**Your Ref: 2026/0354
Our Ref: B/01738**

Land west of Cross Street, Worsbrough Dale, Barnsley - (BARNS) Erection of a residential care home consisting of 6 single bedroom self-contained units and a detached 2 bedroom respite bungalow for young adults (Use Class C2) with associated works including formation of accesses; car parking and landscaping

Thank you for consulting Yorkshire Water regarding the above proposed development. We have the following comments:

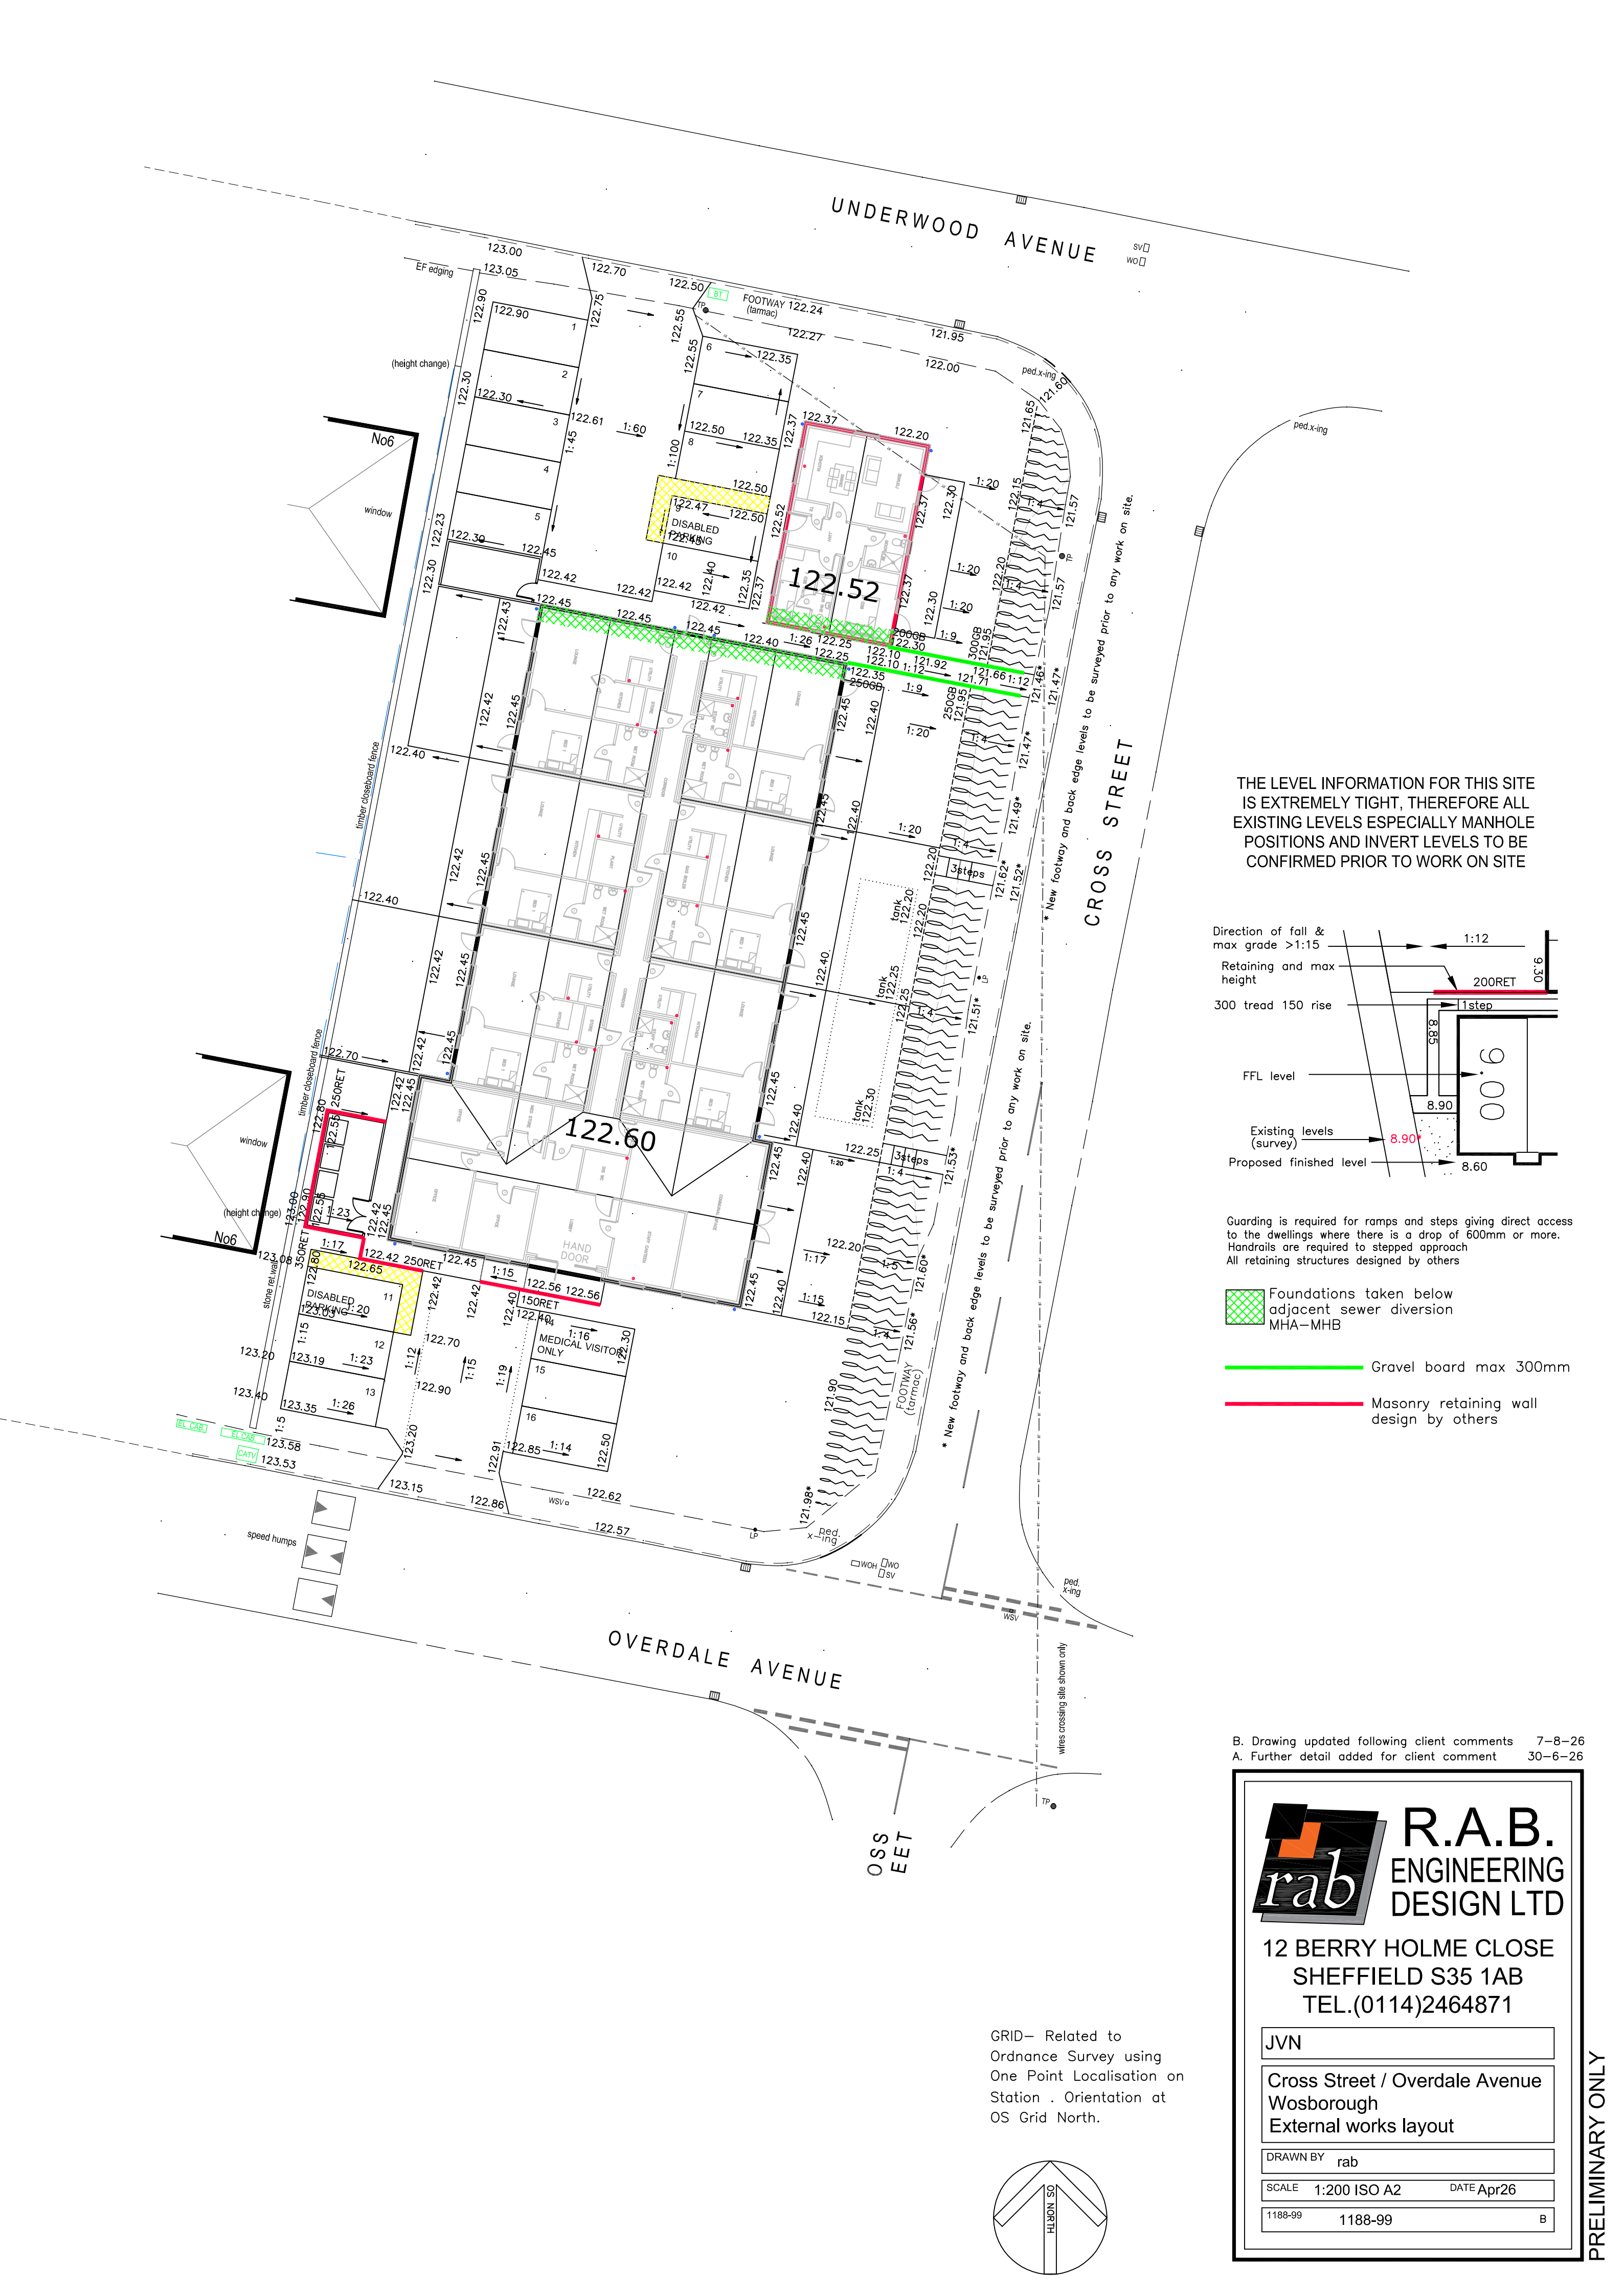
2.) Yorkshire Water has no objection in principle to the drainage details submitted on drawing 'Drainage Layout' 1188-98 (revision D) dated April 26 that has been prepared by RAB, namely: -

- a.) The proposed sewer diversion subject to the requirements of Section 185 Water Industry Act 1991.
- b.) The proposed separate systems of drainage on site and off site with combined
- c.) The proposed amount of domestic foul water to be discharged to the public combined water sewer
- d.) The proposed amount of curtilage surface water to be discharged to the public combined water sewer at a restricted rate of 3.5 litres/second.
- e.) The proposed point(s) of discharge of foul and surface water to the respective public sewer.

On the Statutory Sewer Map, there is an unknown diameter foul water sewer, and a 150mm diameter public combined water sewer recorded to cross the site. It is essential that the presence of this infrastructure is taken into account in the design of the scheme.

It may not be acceptable to raise or lower ground levels over the sewer and we will not accept any inspection chambers on the sewer to be built over.

It is understood that this will be diverted subject to Yorkshire Water's requirements and formal procedure in accordance with Section 185 Water Industry Act 1991 - Yorkshire Water would look for this matter to be controlled (by Requirement H4 of the Building Regulations 2010 - H4S185).

The site shall be developed with separate systems of drainage for foul and surface water on and off site. The separate systems should extend to the points of discharge to be agreed, details of which will have been submitted to and approved by the Local Planning Authority
(In the interest of satisfactory and sustainable drainage)

There shall be no piped discharge of surface water from the development prior to the completion of surface water drainage works, details of which will have been submitted to and approved by the Local Planning Authority. If discharge to public sewer is proposed, the information shall include but not be exclusive to:

i) the means of discharging to the public sewer network at a rate not to exceed 3.5 litres per second.
